CITY OF ALBUQUERQUE

RE: **700 Tijeras**
700 Tijeras Ave NW
Grading and Drainage Plan
Engineer's Stamp Date: 7/15/19
Hydrology File: K14D117

Based on the submittal received on 7/15/19, the Grading and Drainage Plan cannot be approved for Building Permit until the following corrections are made:

Sheet:
Grading and
Drainage Plan

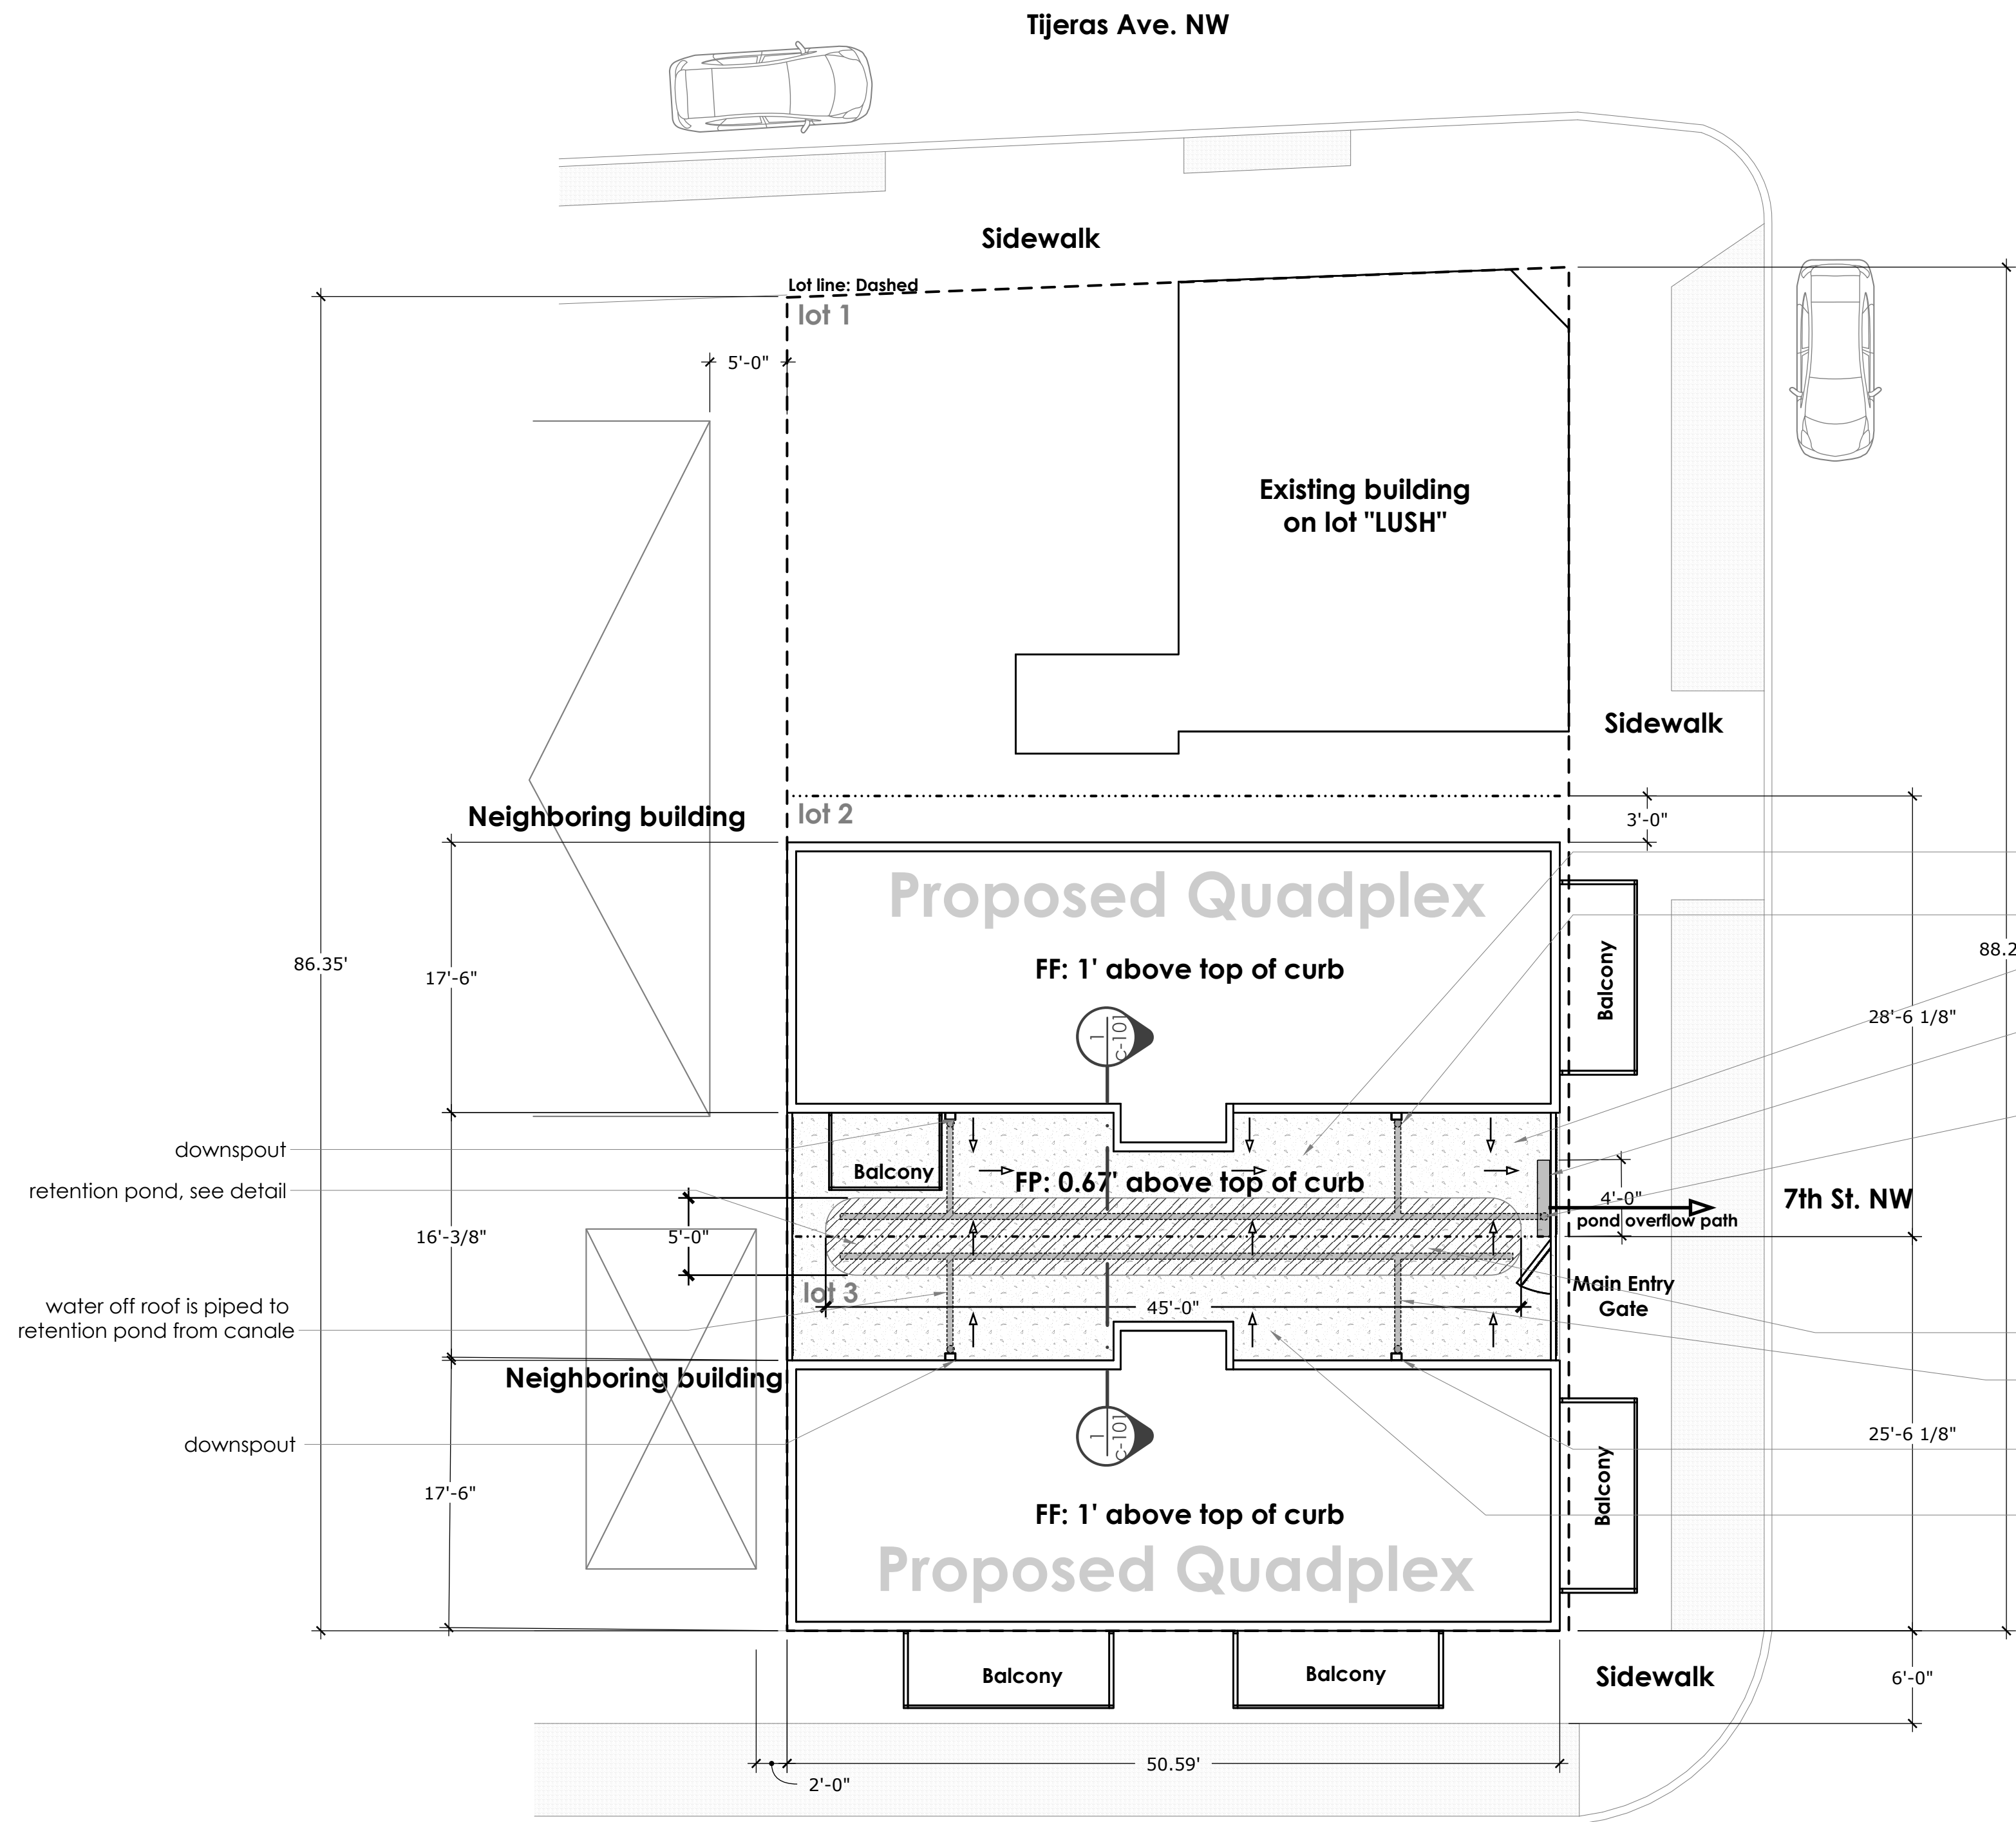
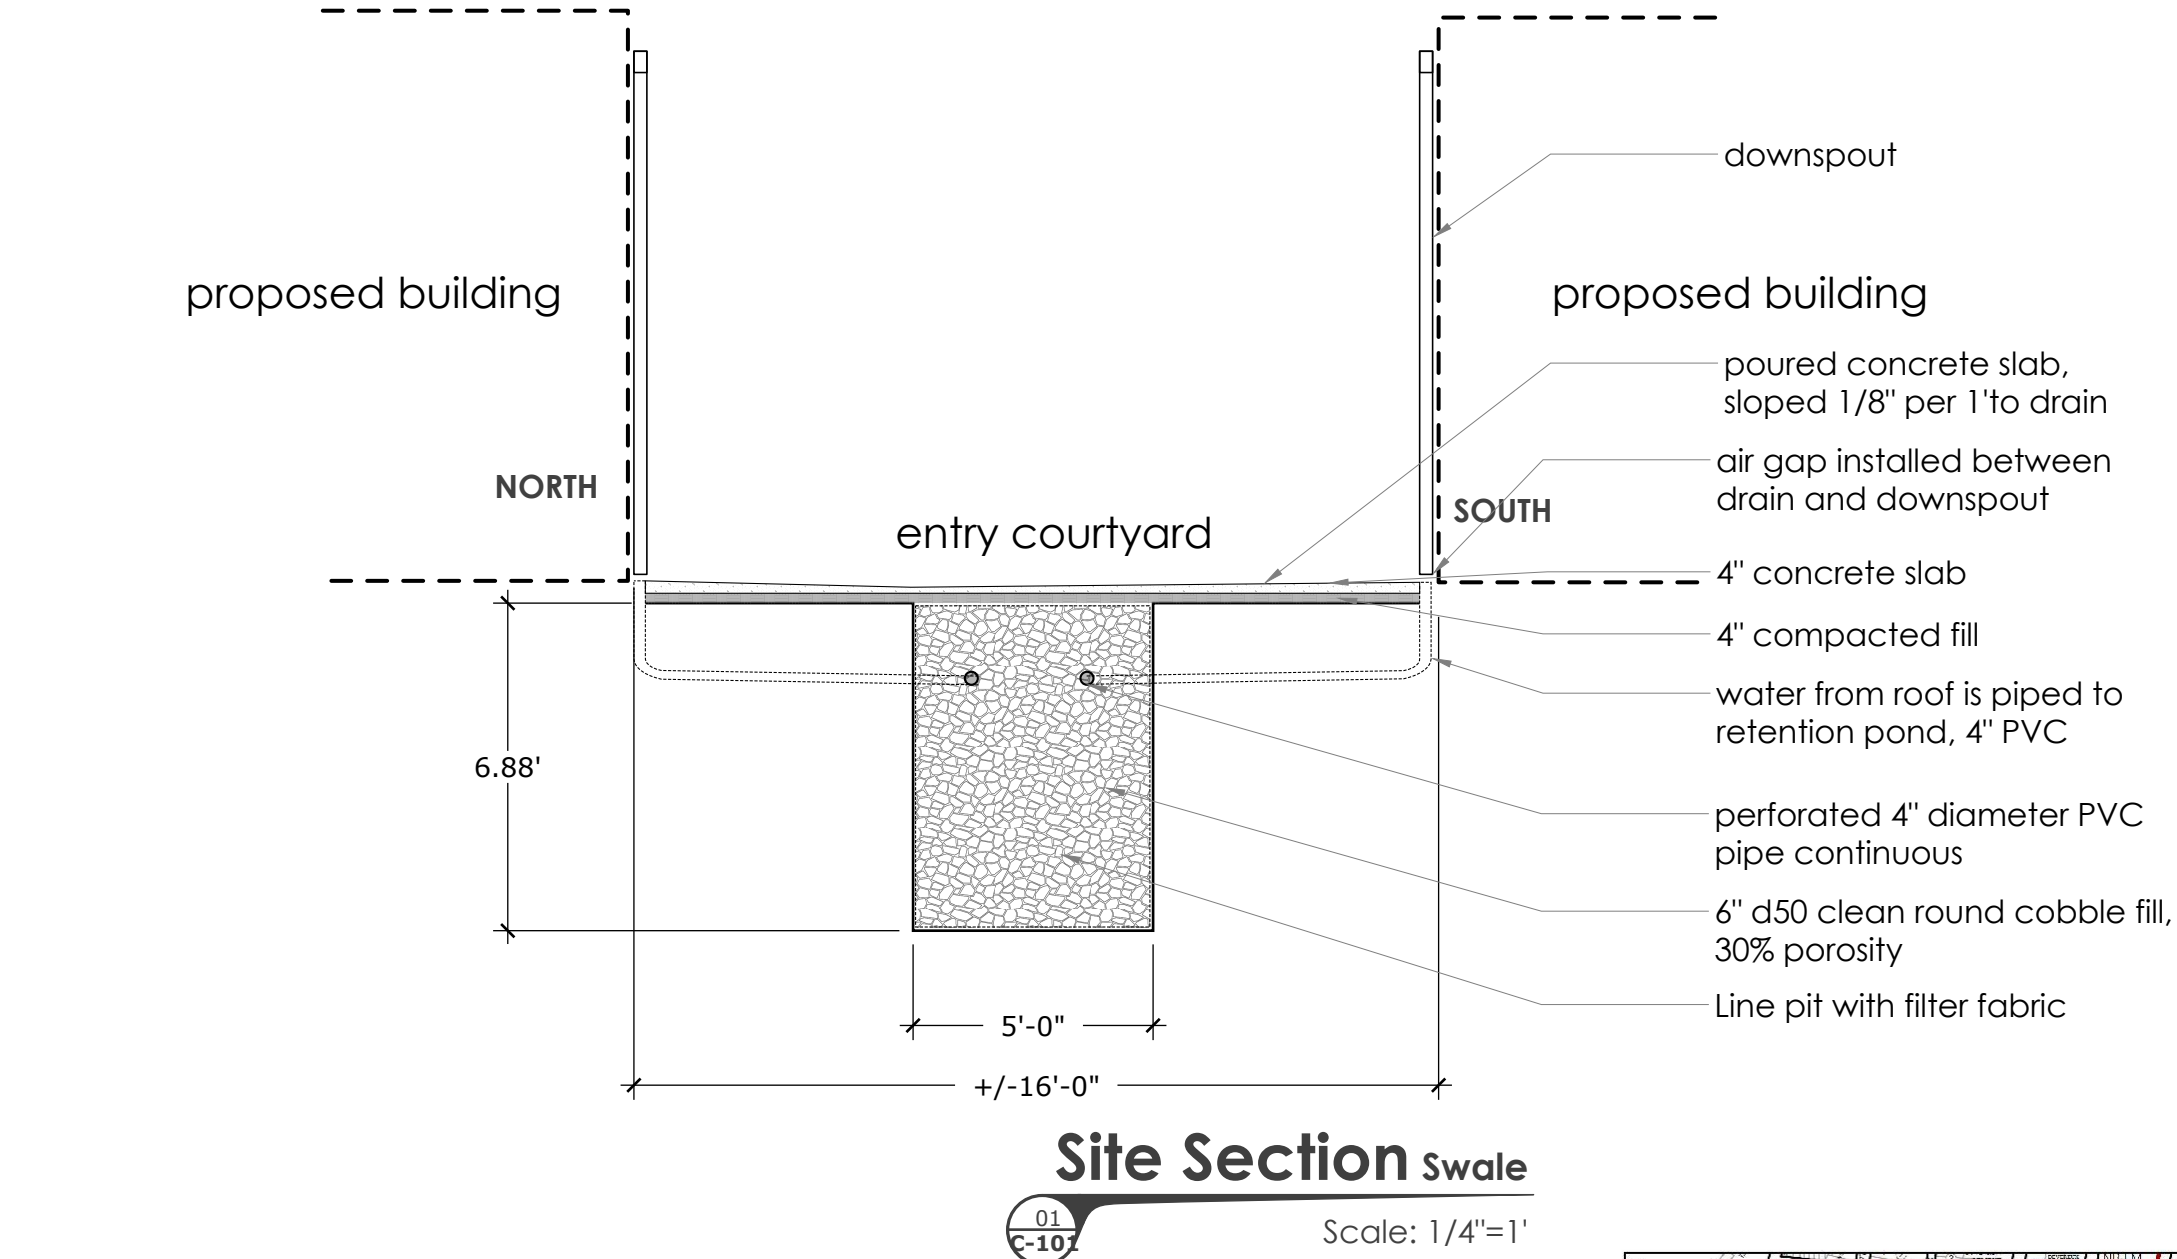
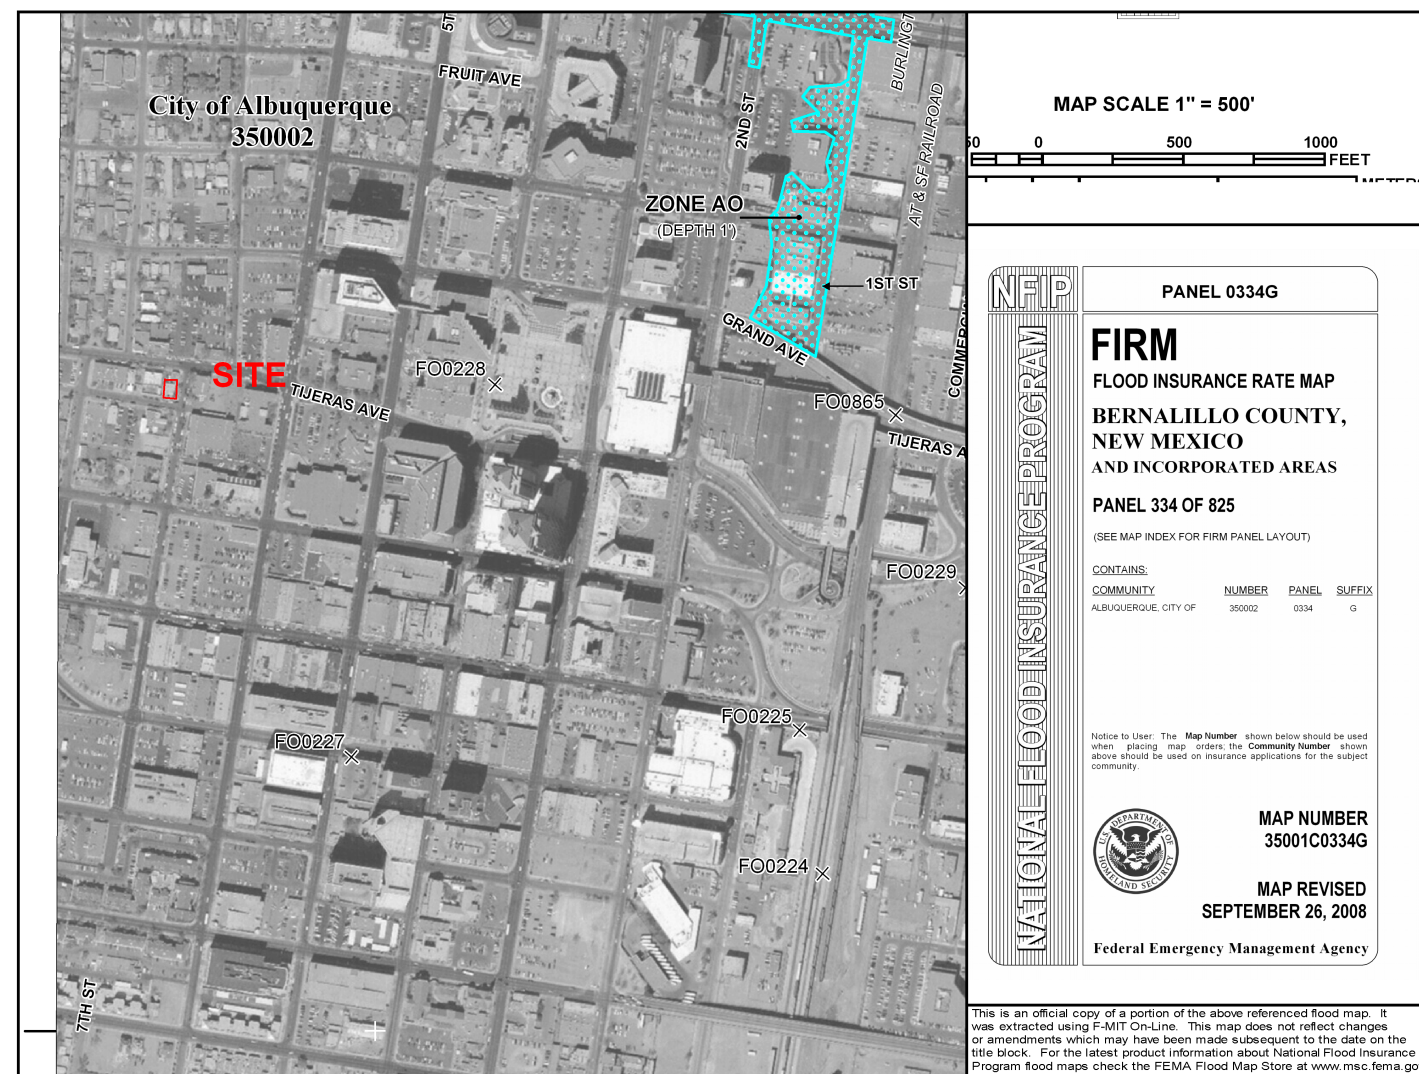
1. The temporary benchmark needs to be tied to a permanent monument, preferably part of the Albuquerque Geodetic Reference System (AGRS).
2. The drawing needs to be scaled to a common-use engineer's scale (not architect's) such as 1"=20' or 1"=10'.
3. For Information. This project will require a revocable permit for the balconies overhanging the ROW. Please contact the City Engineer (Shahab Biazar, sbiazar@cabq.gov) for more information.
4. Because these corrections are minor, the administrative resubmittal fee of \$40 may be used. Please include a copy of this letter when resubmitting in order to receive the reduced fee.
